A47 Blofield to North Burlingham

Scheme Number: TR010040

8.13 Statement of Common Ground with Highways England and Blofield Parish Council

Statement of Common Ground – Blofield Parish Council

GENERAL ARRANGEMENT PLANS  
REGULATION 5(2)(o)  
SHEET 7 OF 8

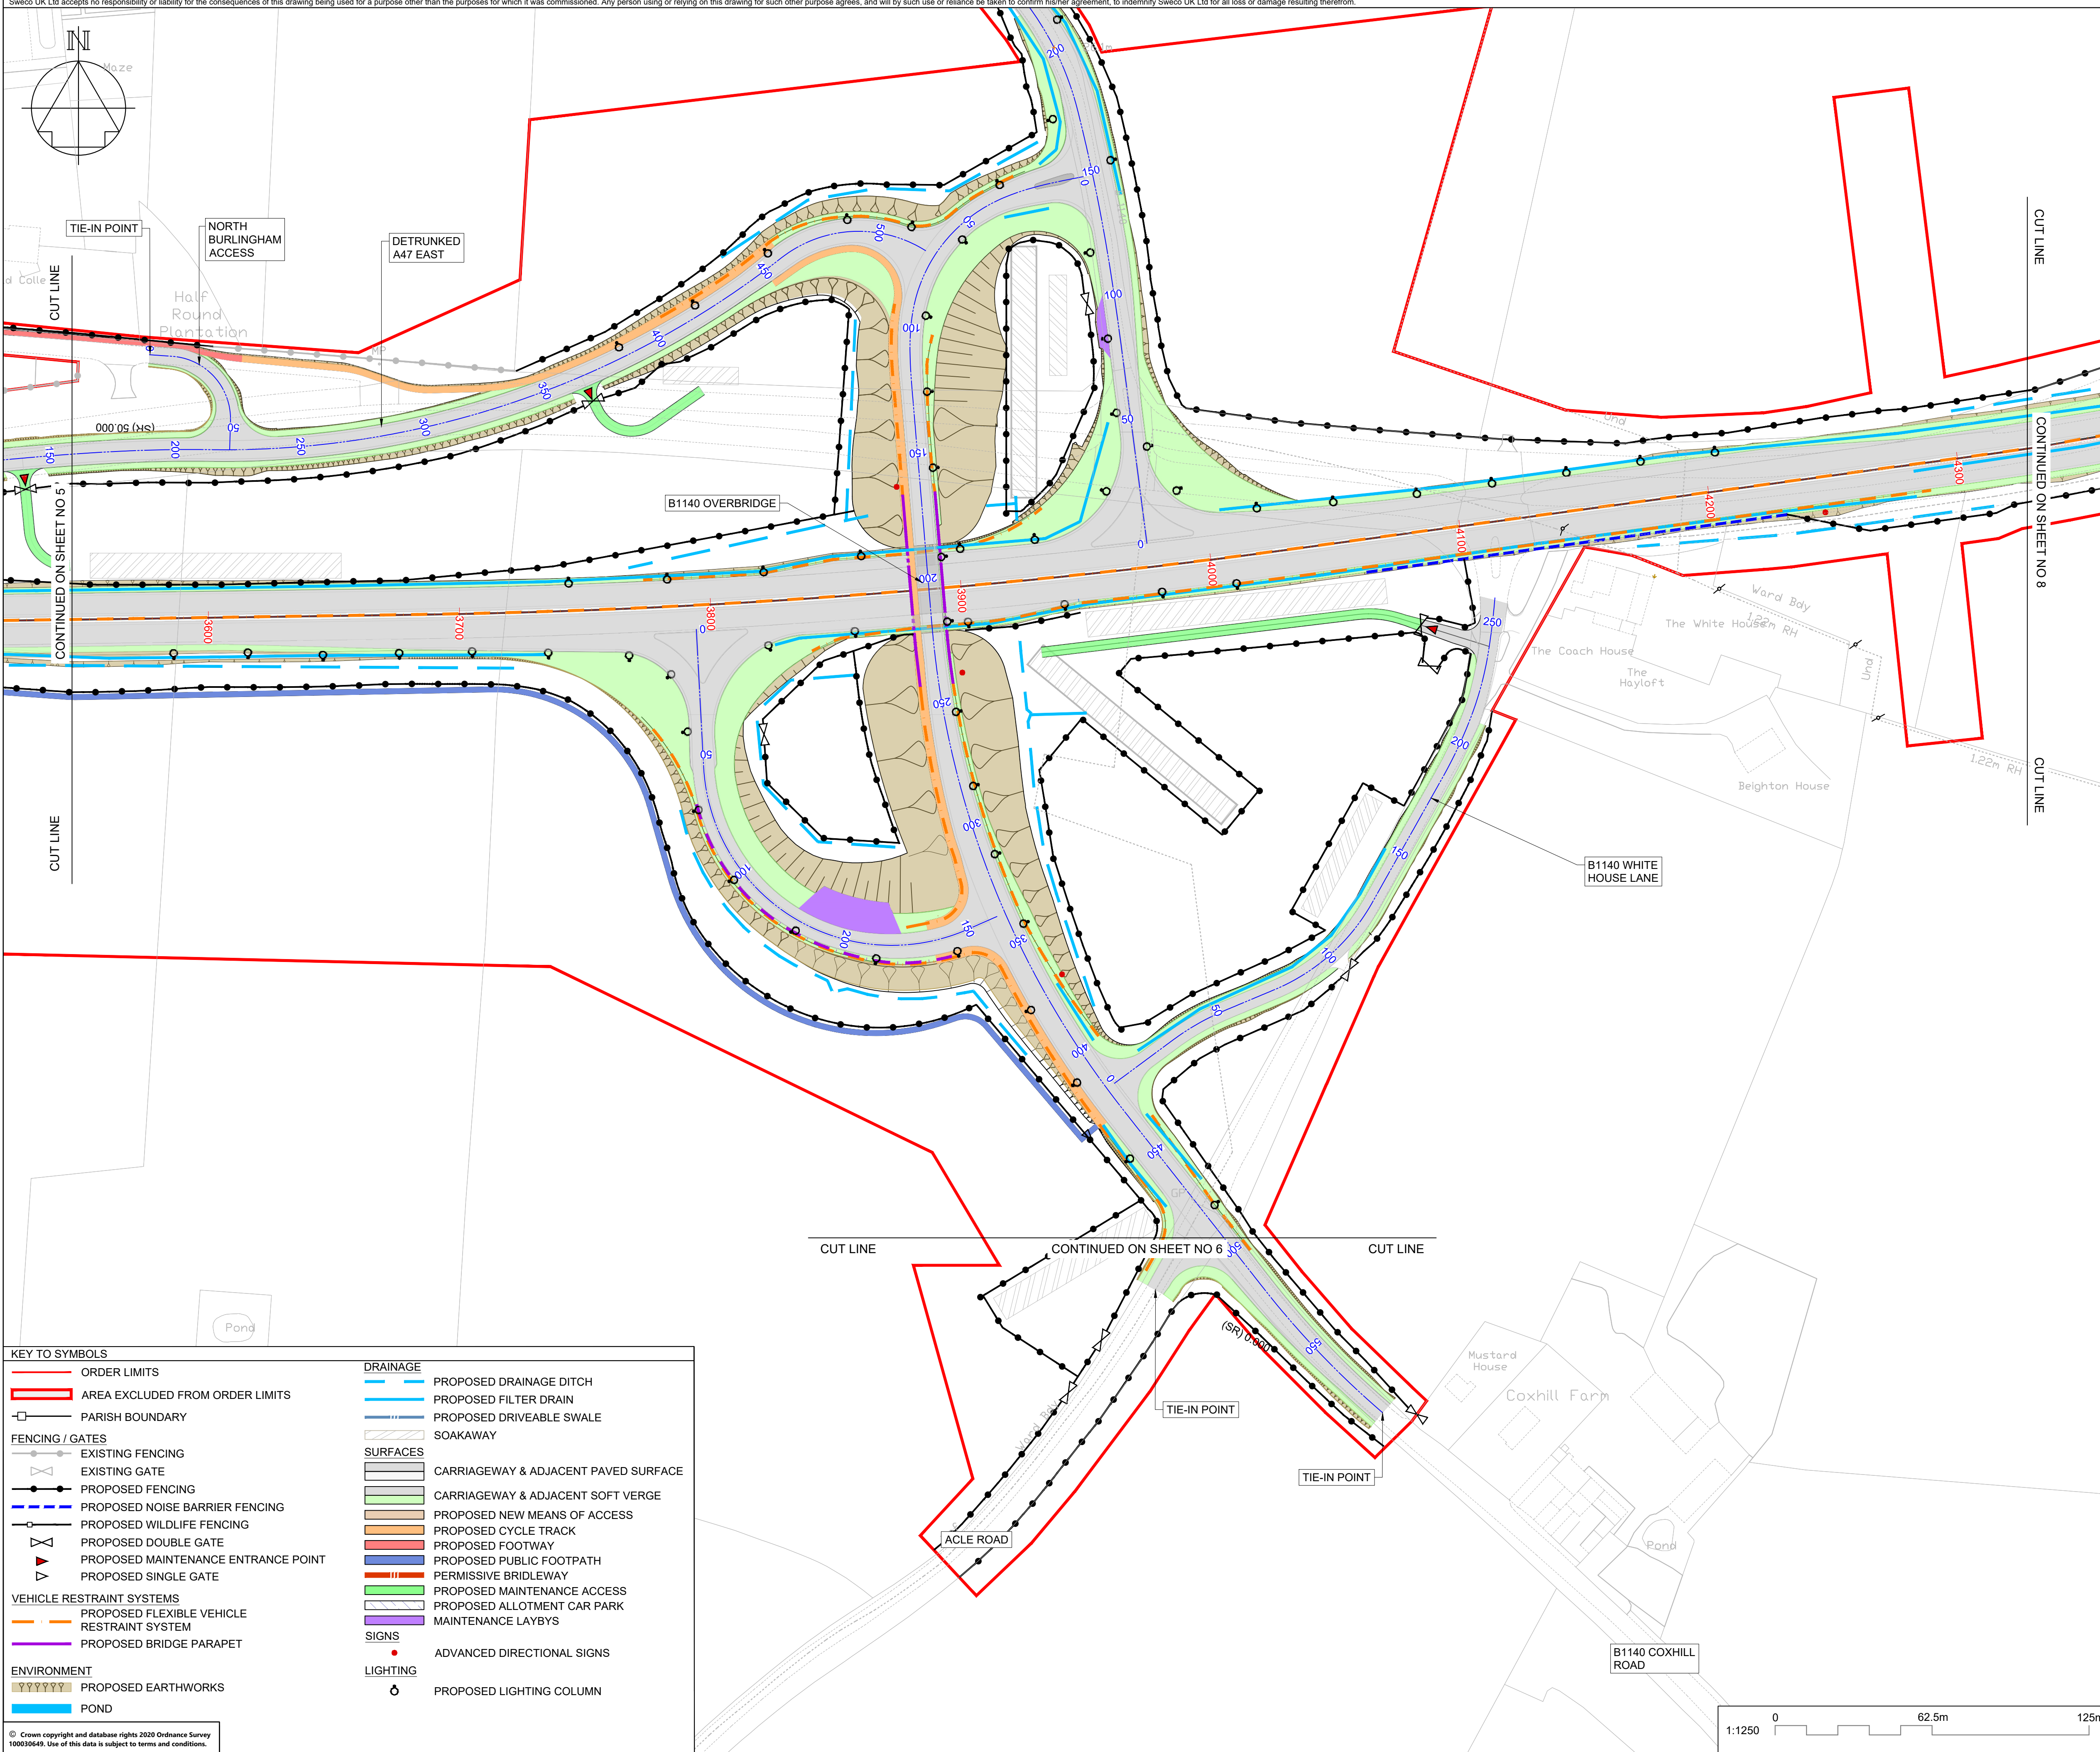
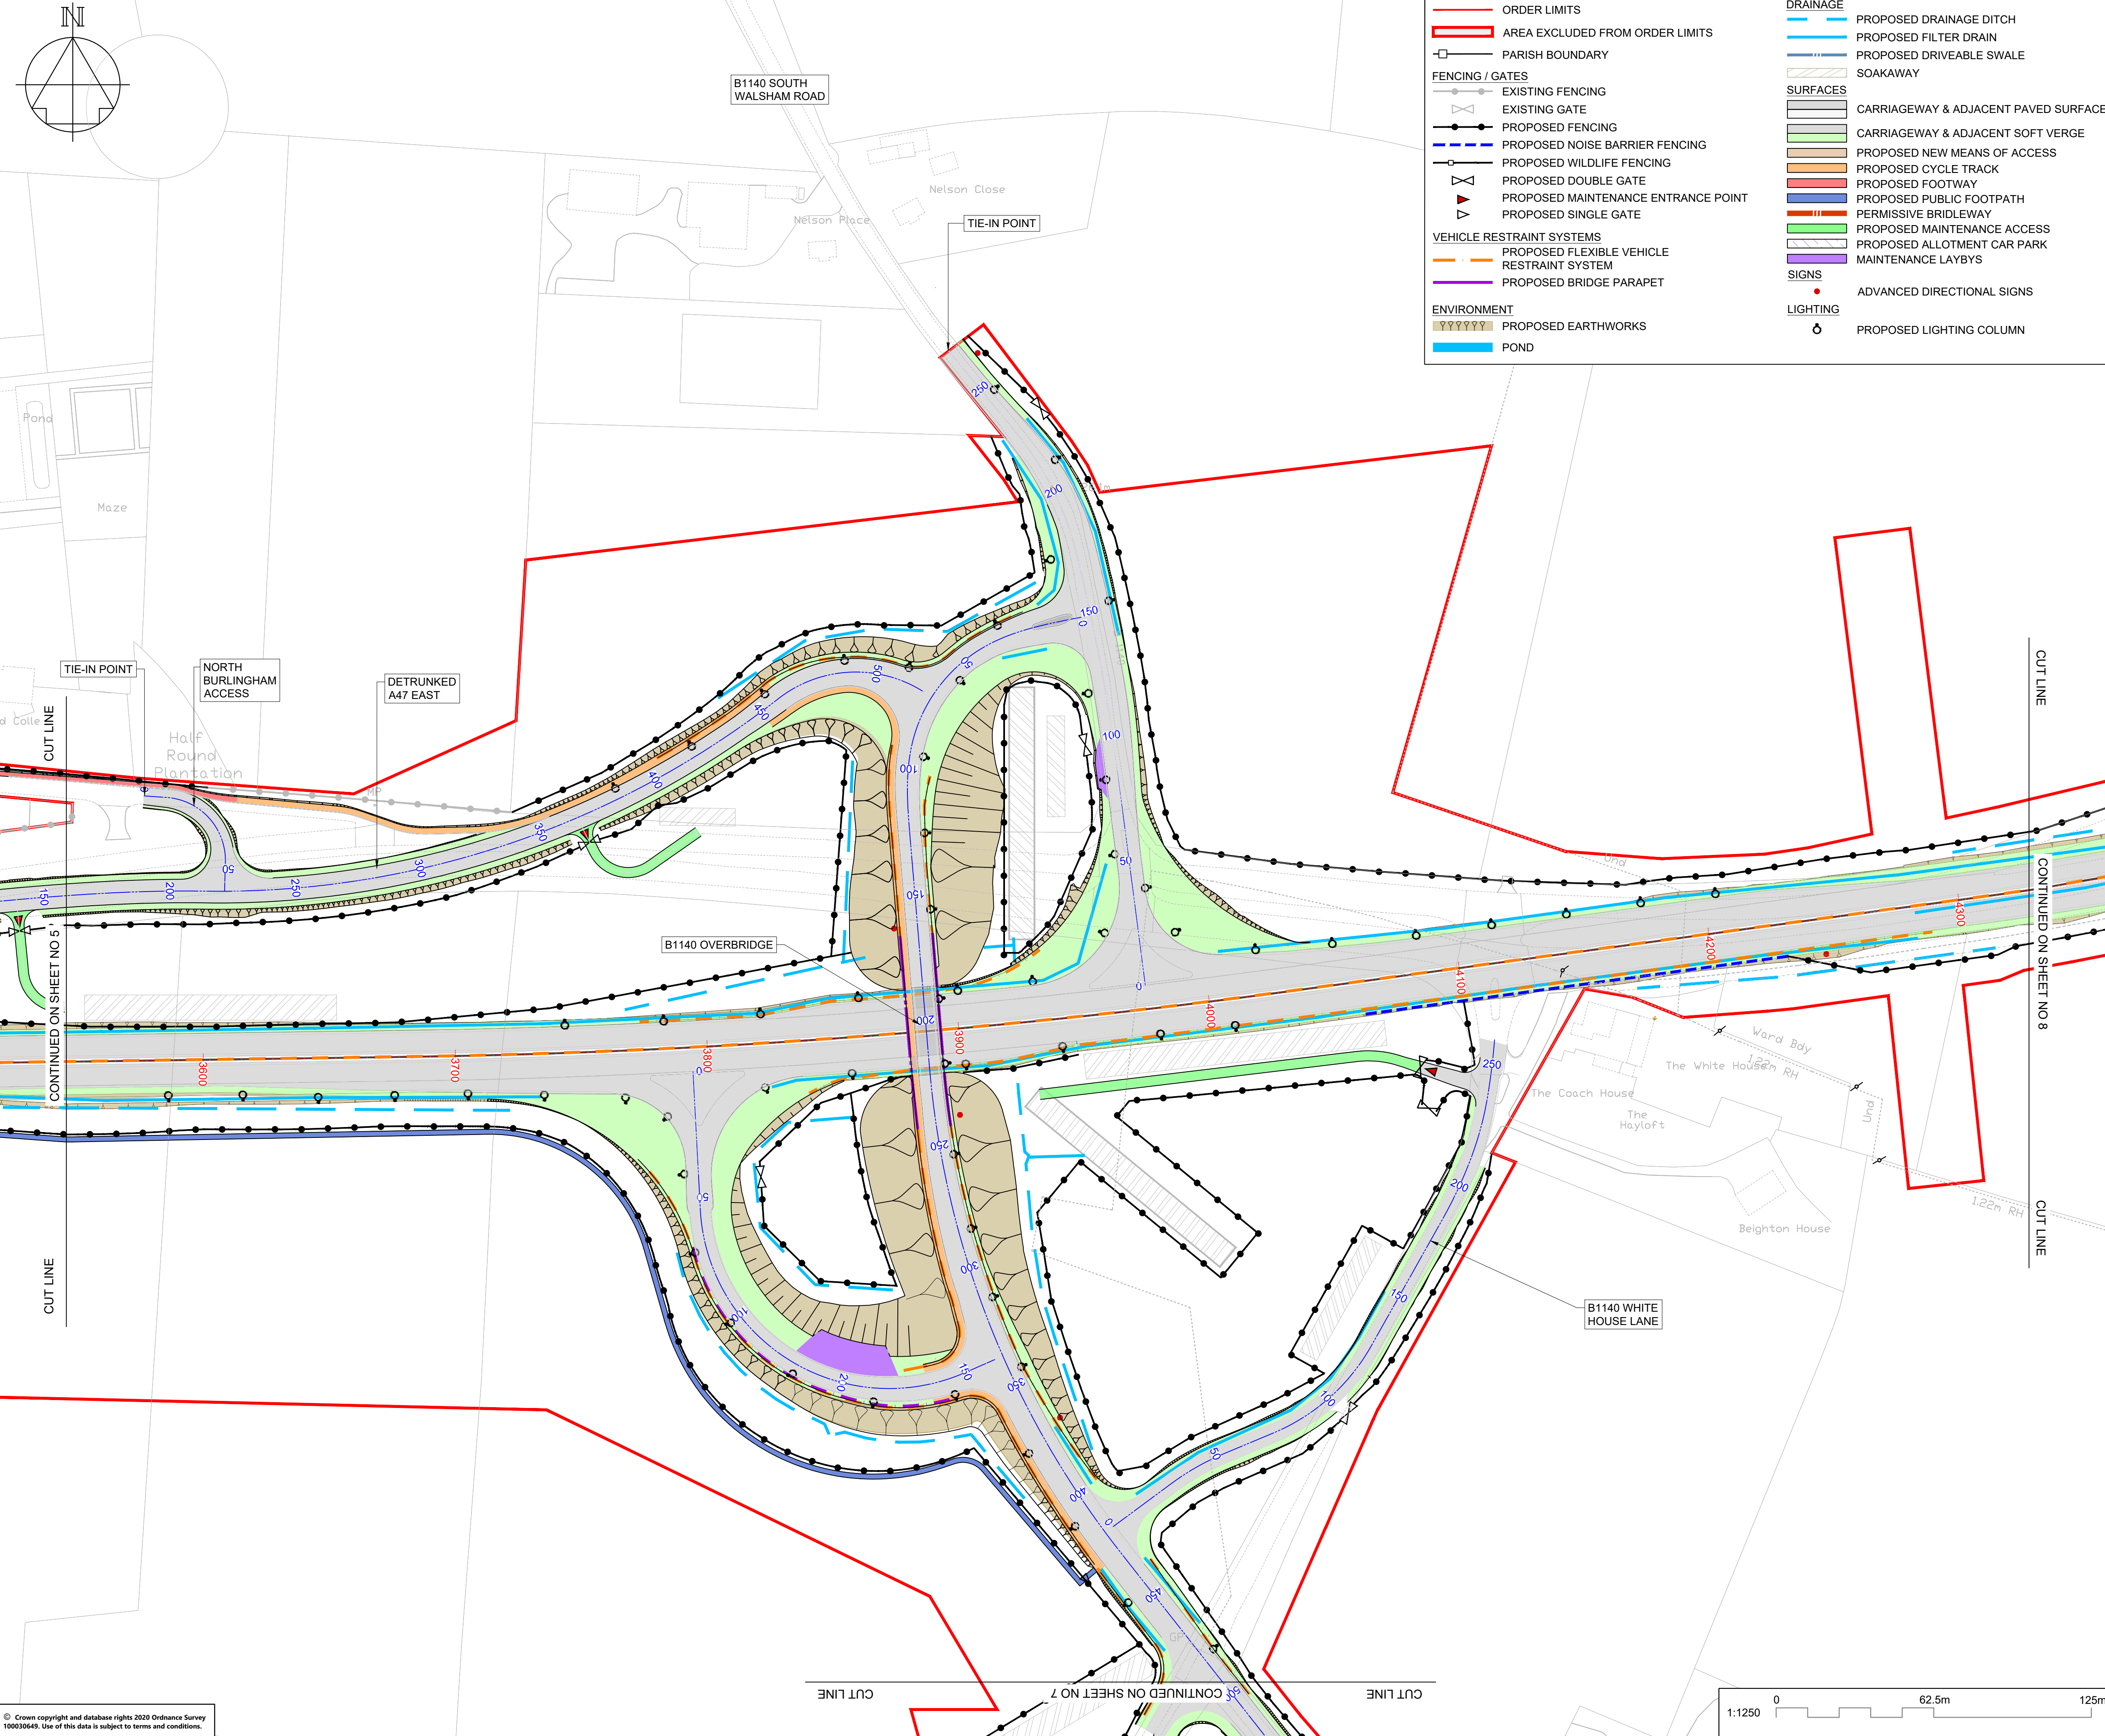
Road Lighting	Letter from BPC in Appendix C	2.6 General Arrangement Plans The proposed 20 lighting columns would be in contradiction of the Blofield Neighbourhood Plan	As described in the Scheme Design Report (APP-122) lighting is proposed at the Yarmouth Road as road safety mitigation.
